Development Application and Planning Proposal Review NSW Planning Portal Concurrence and Referral

Address	Land Title
93-107 CECIL AVENUE & 9-10 ROGER AVENUE, CASTLE HILL	Various lots

Environmental Impact Statement (EIS) for the Mixed-use development with in-fill affordable housing - Cecil Avenue and Roger Avenue, Castle Hill. Demolition of existing buildings and construction of a mixed-use development comprising at least 8,025 square metres of commercial floor space and approximately 617 apartments. The development ranges from 5 to 25 storey buildings.

EXISTING POWER INFRASTRUCTURE

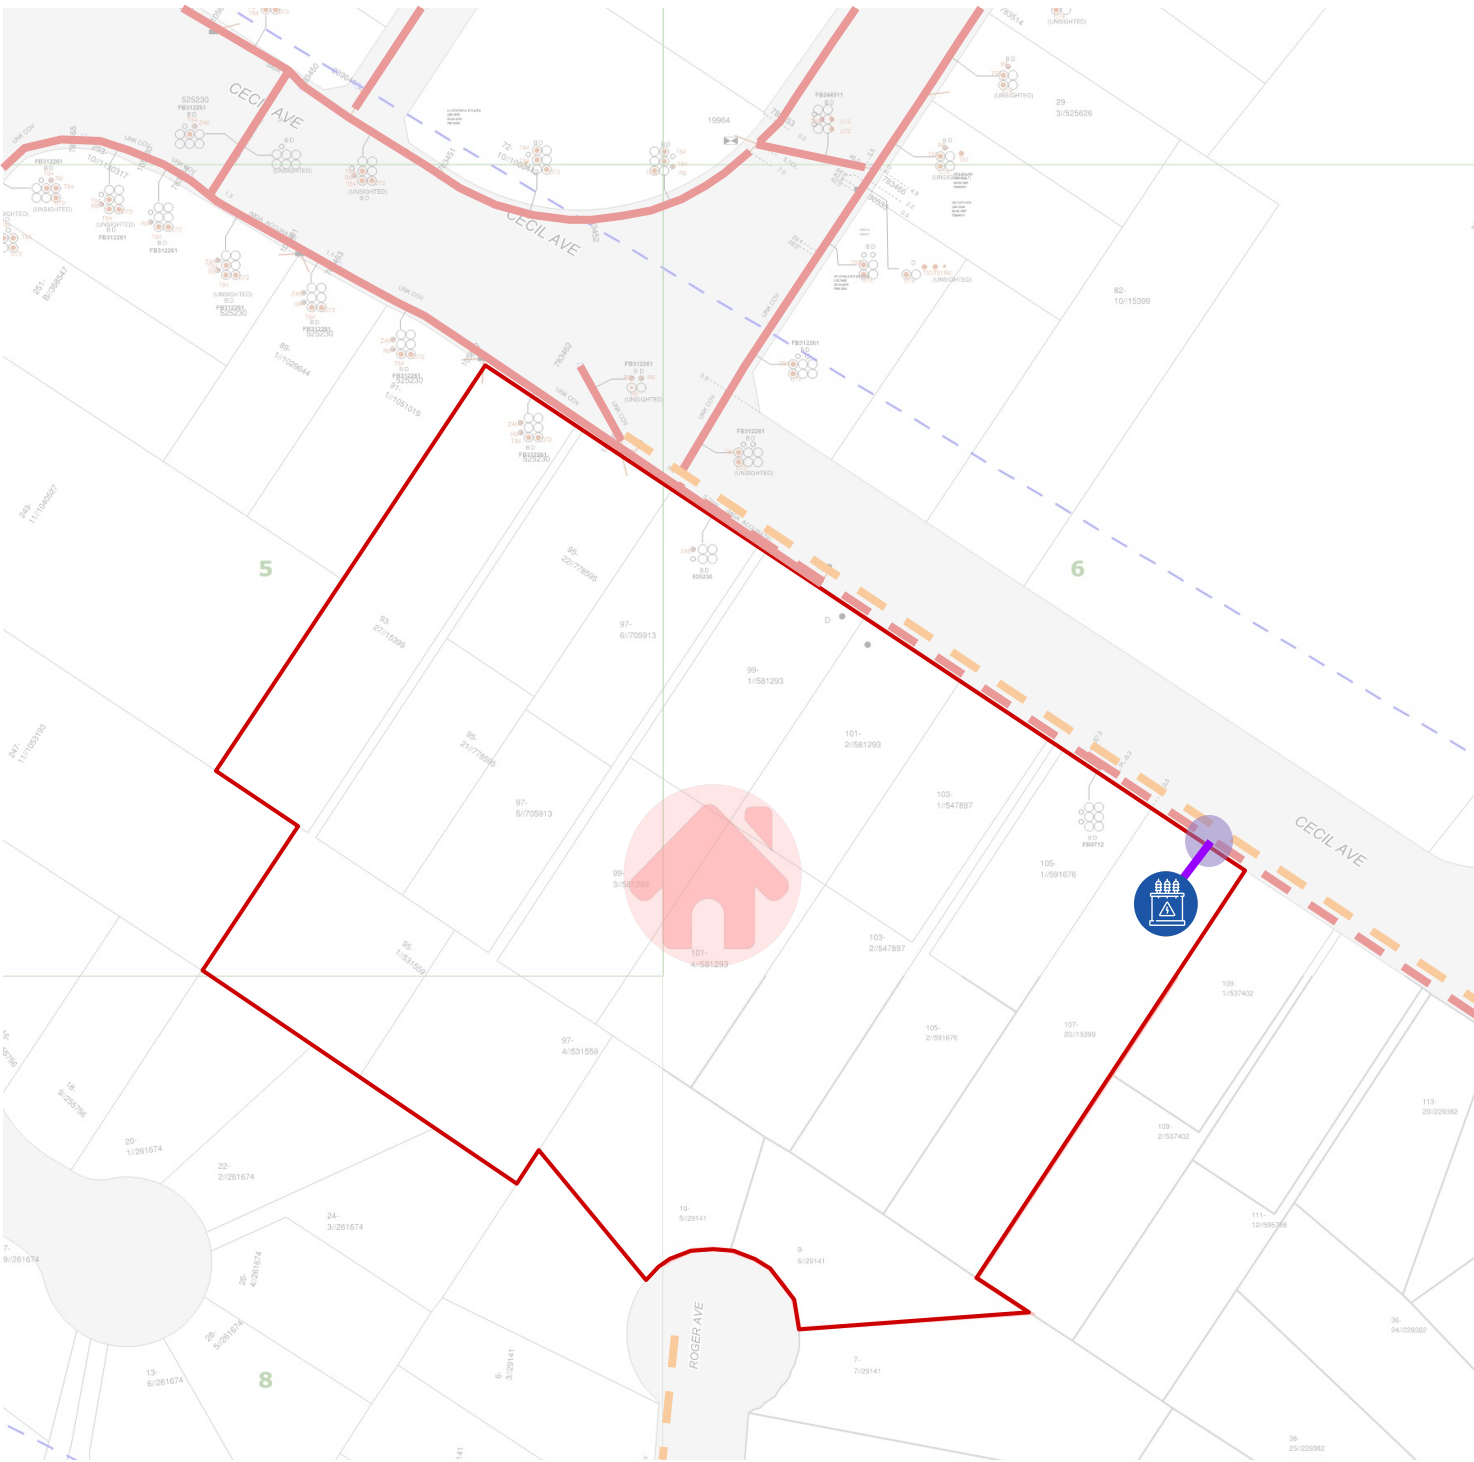
- The low voltage service conductor and customer connection point must comply with the current 'Service and Installation Rules of NSW'.
- The Infrastructure Delivery, Management and Staging Plan prepared by Neuron dated 2024-12-10 - Revision 01 includes the following addressing whether electricity services are available and adequate for the development.

The site will likely require a new substation with three x 1,500kVA transformers.

The below copy of the Upper Ground Plan shows provision for an (indoor) substation to the Cecil Avenue road frontage.
